From: David Fuller [REDACTED]
Sent: 02 September 2015 17:54
To: Ross Leal
Cc: AFA Fuller
Subject: Wide Horizon, Aldwick - AW/208/15/HH

Proposed Plans

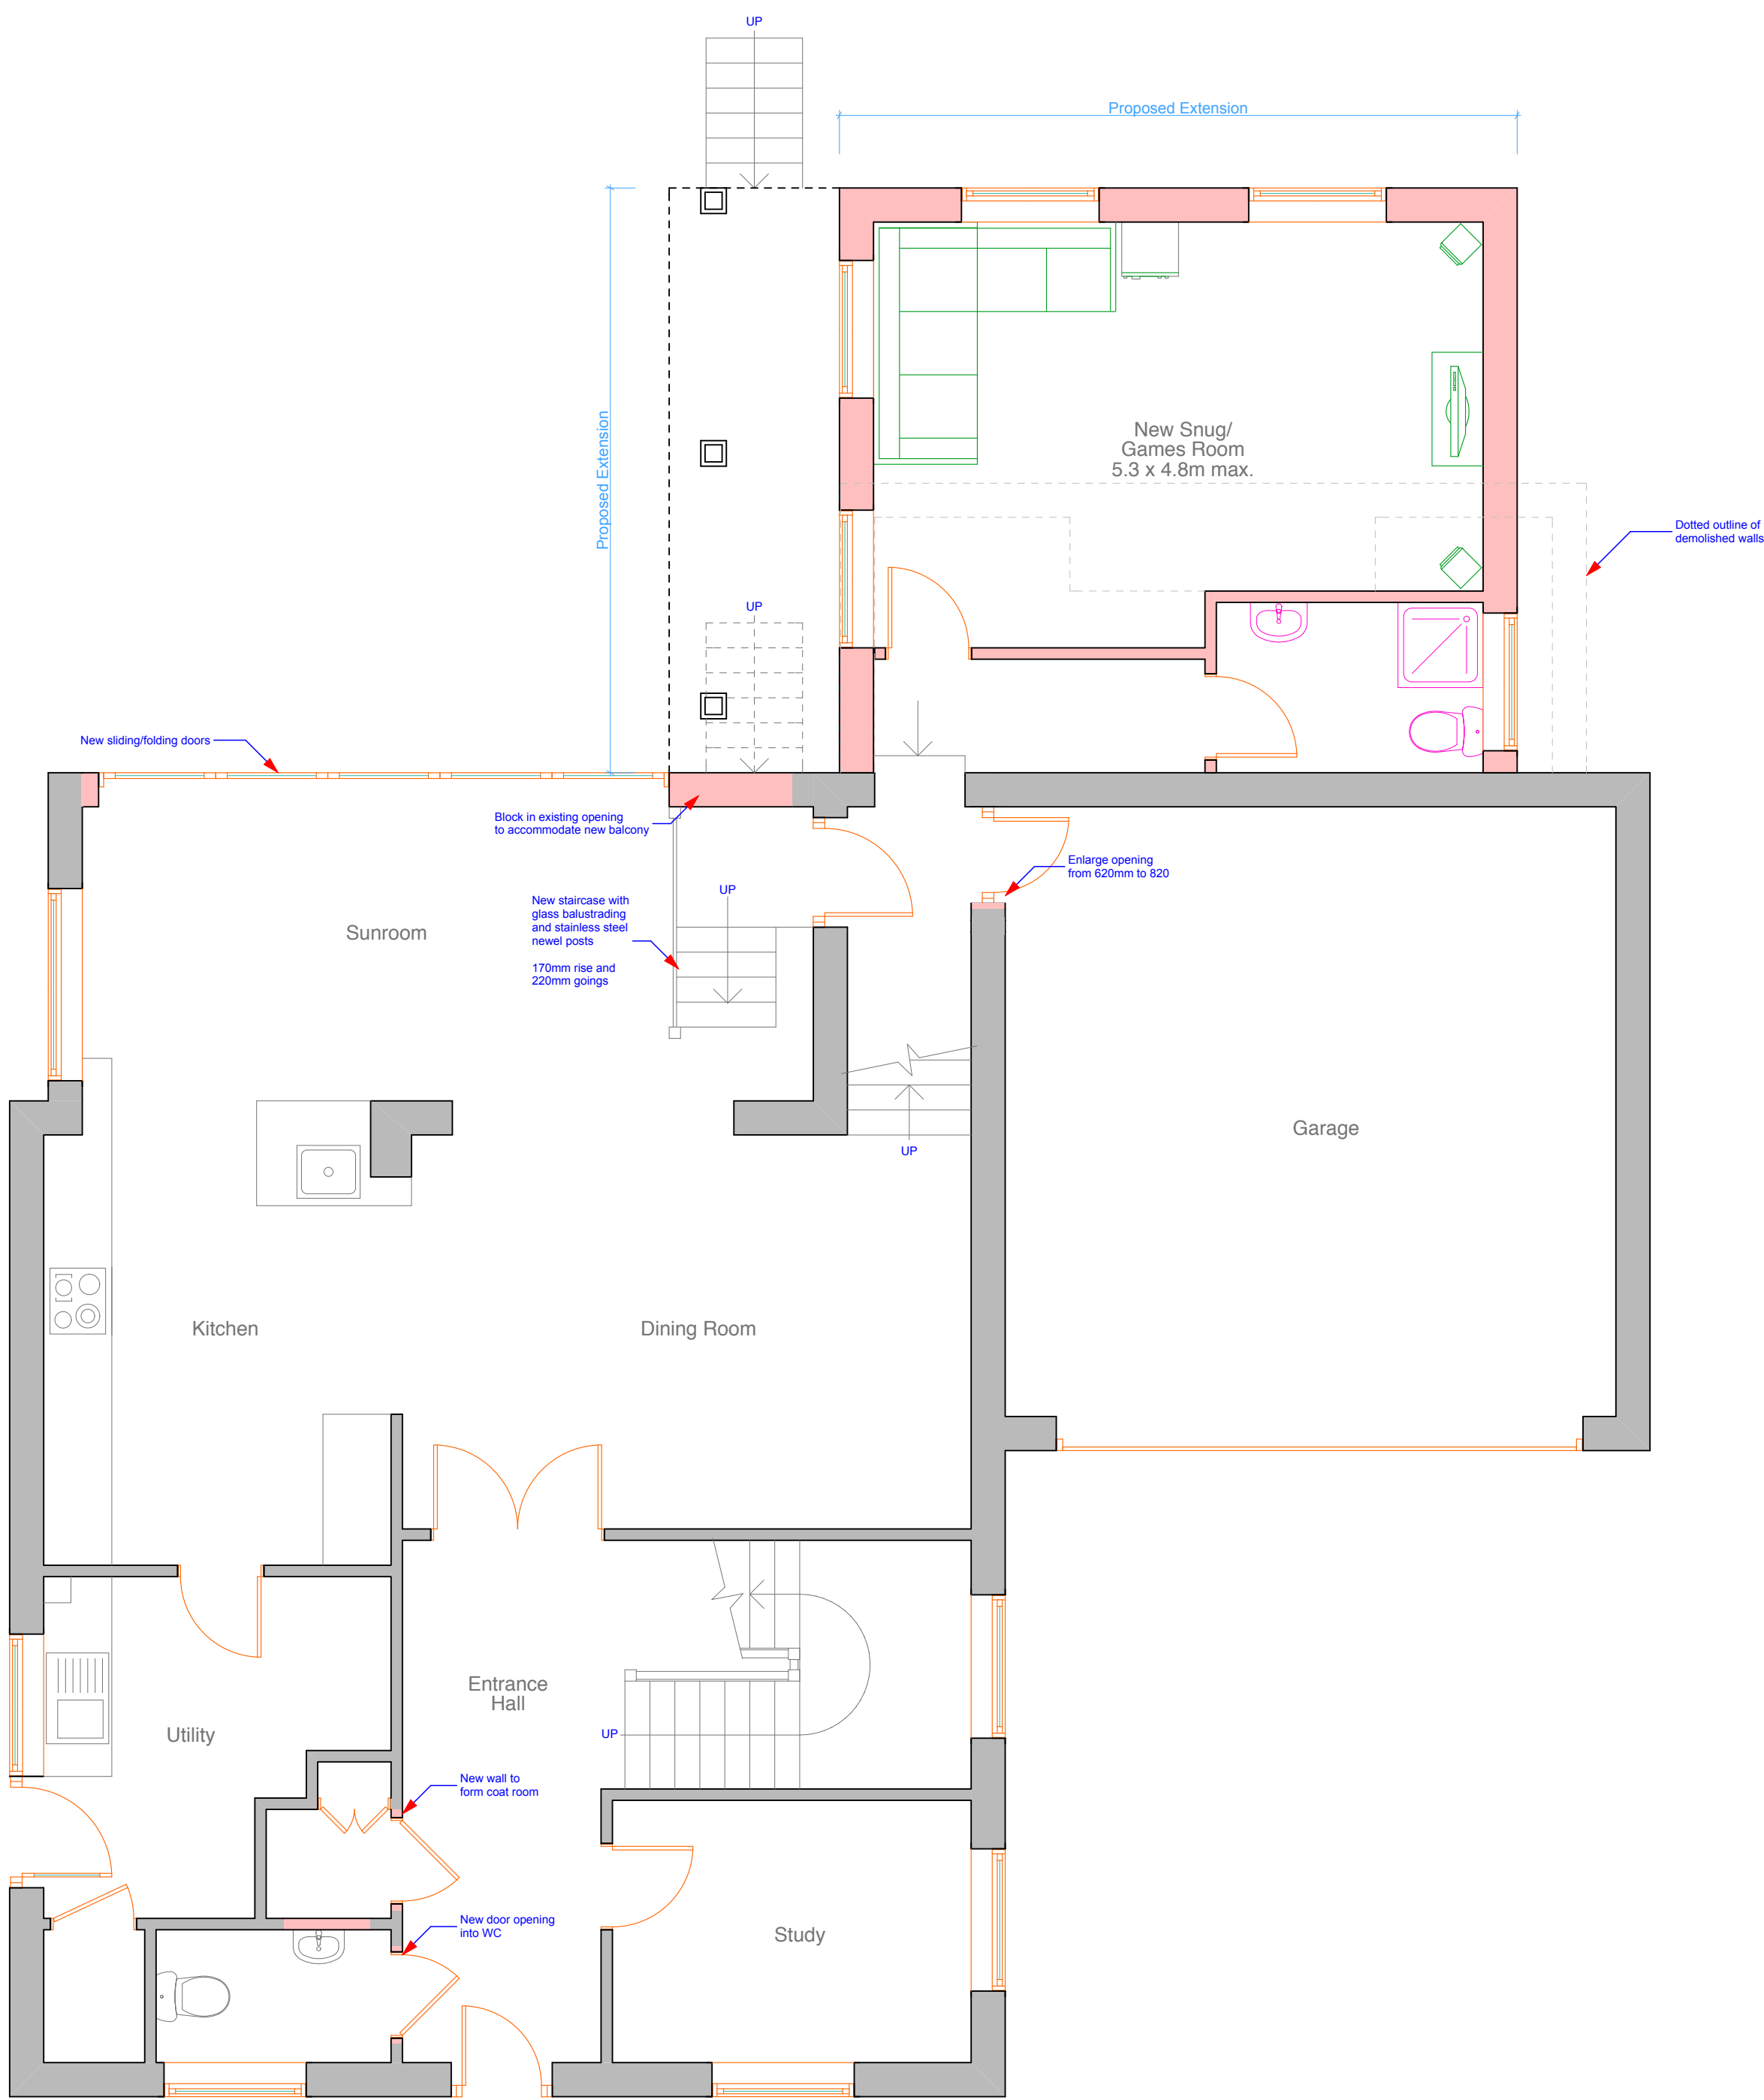
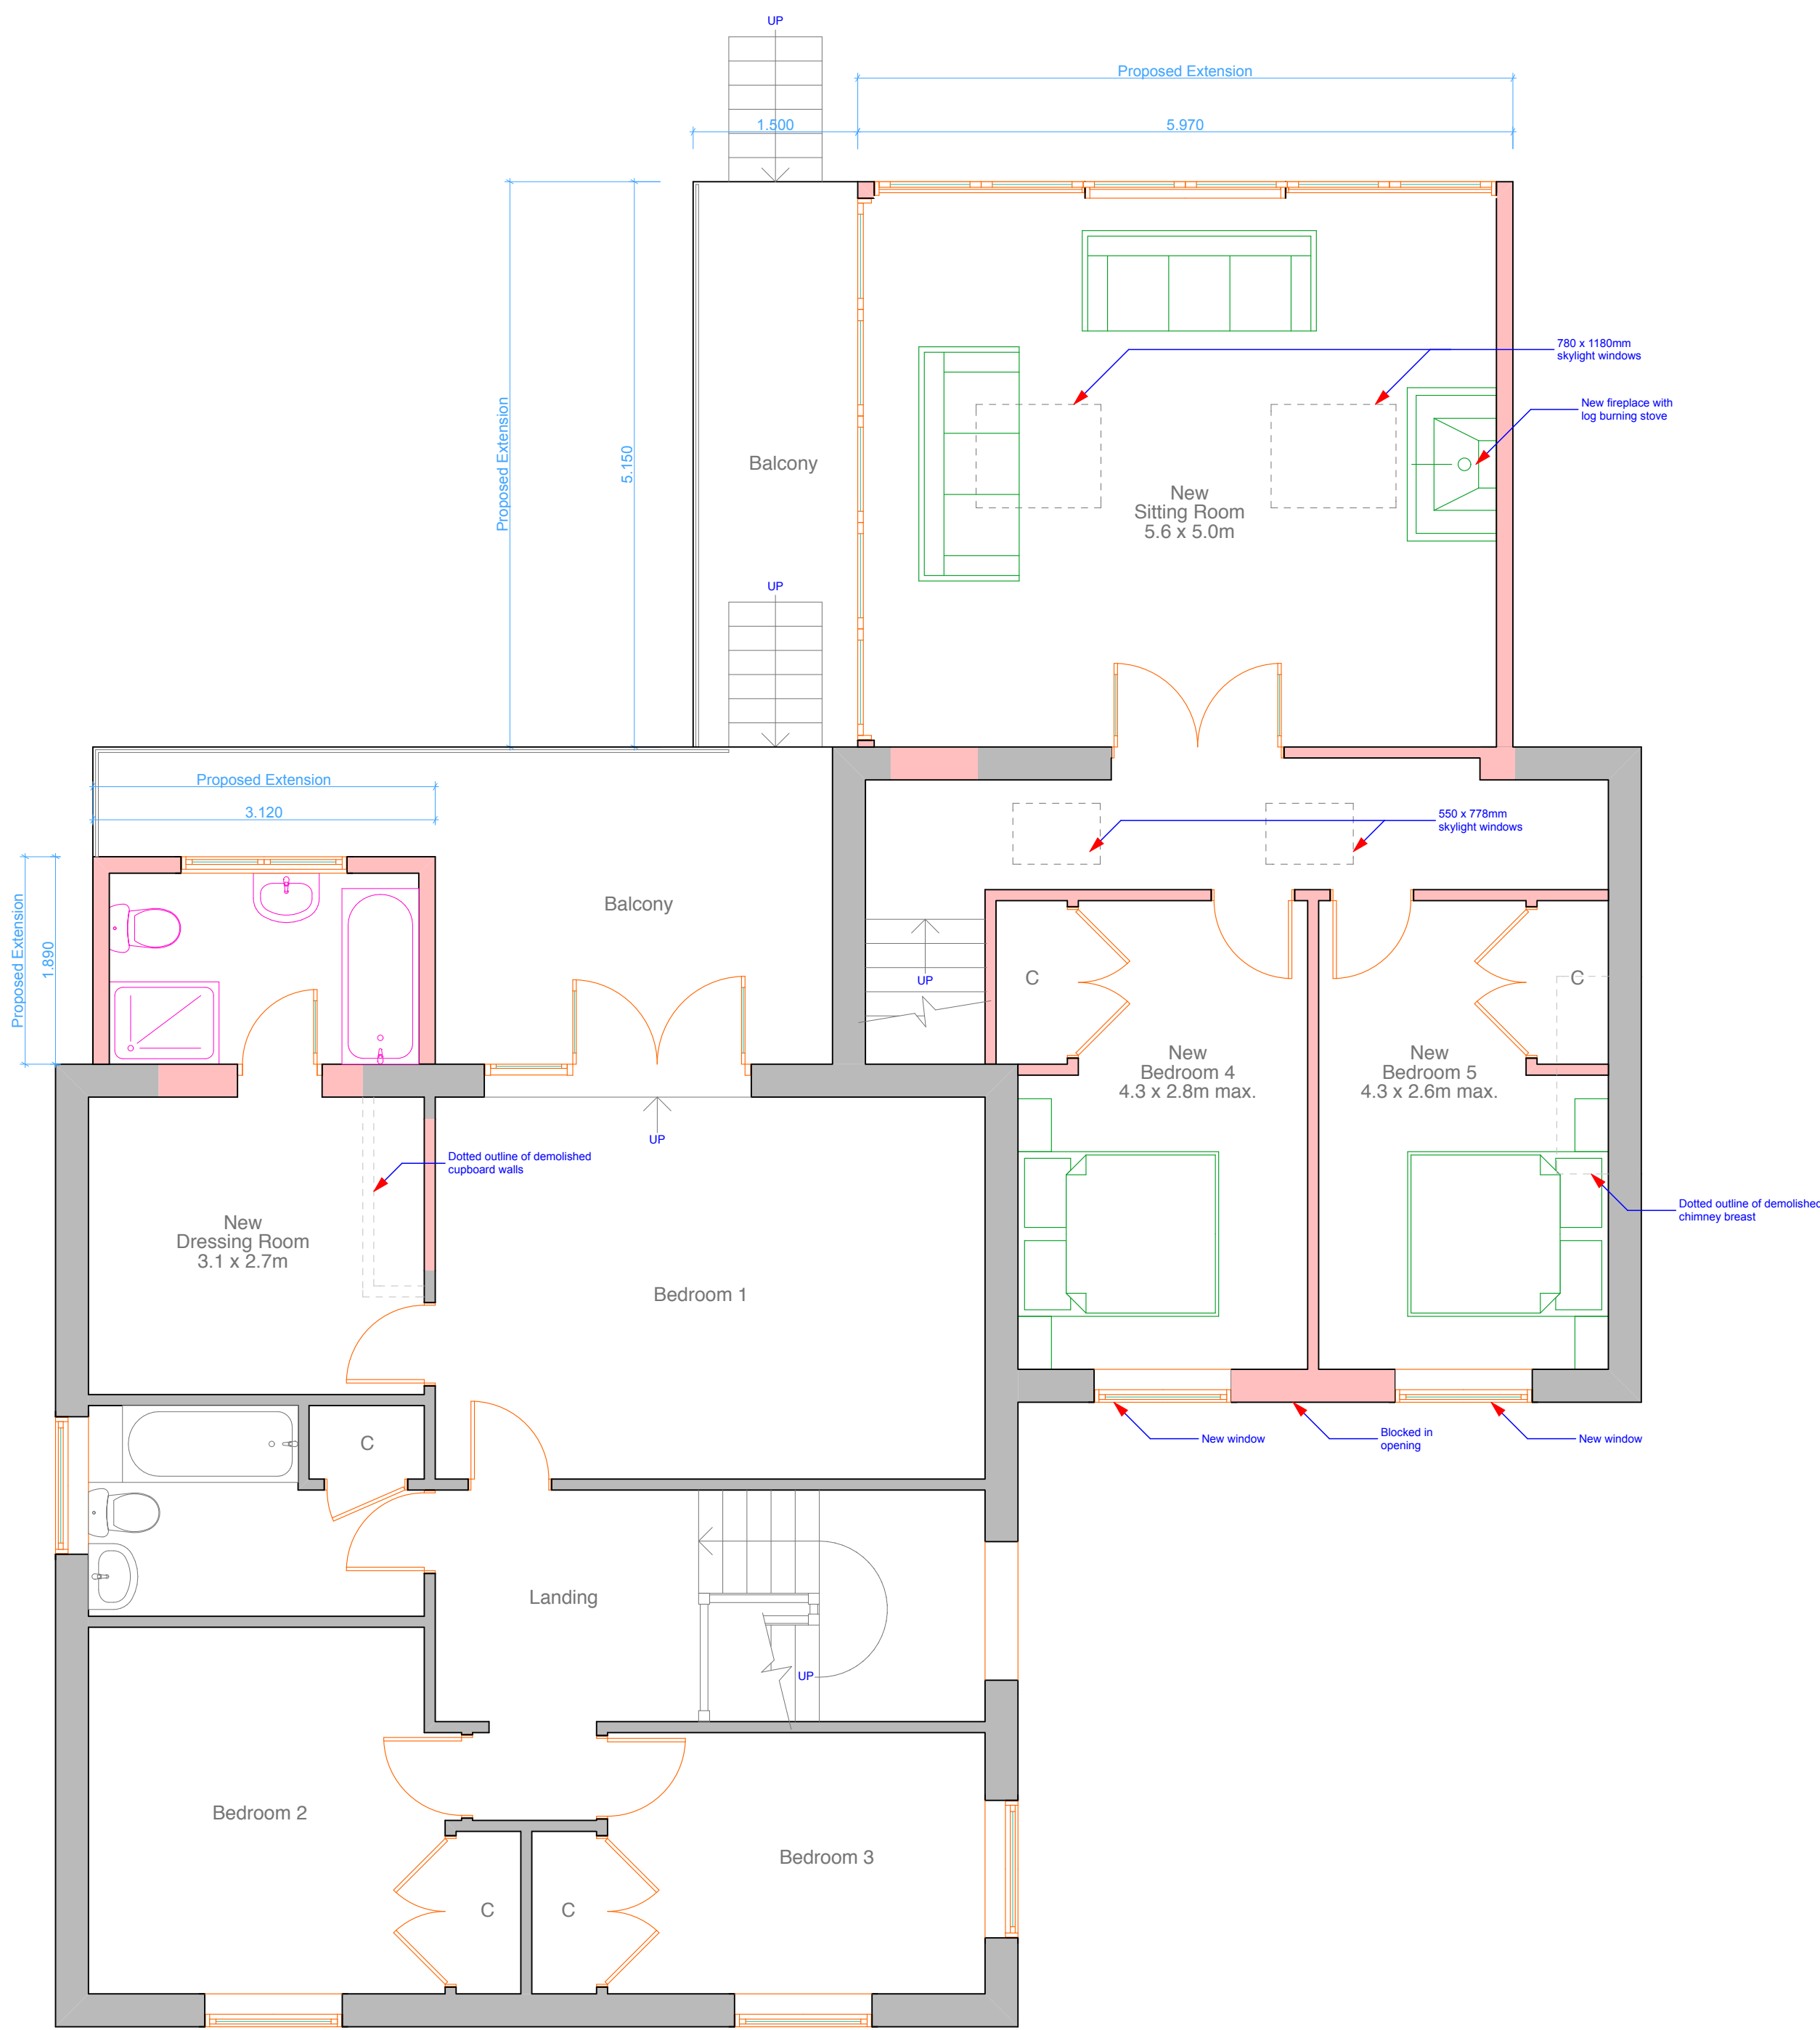
Please find attached revised proposed plans and elevations drawings, which include the provision of a balcony privacy screen to the East Elevation, and consequently altered access steps to the lower balcony, in line with our discussion on the telephone this afternoon. We feel that this adequately mitigates any obtrusive overlooking from our clients property into the neighbouring No.9 Waters Edge to the East of Wide Horizon, and we hope this goes some way to alleviate Mr & Mrs Leech's concerns to the proposal raised in their representation to the council.
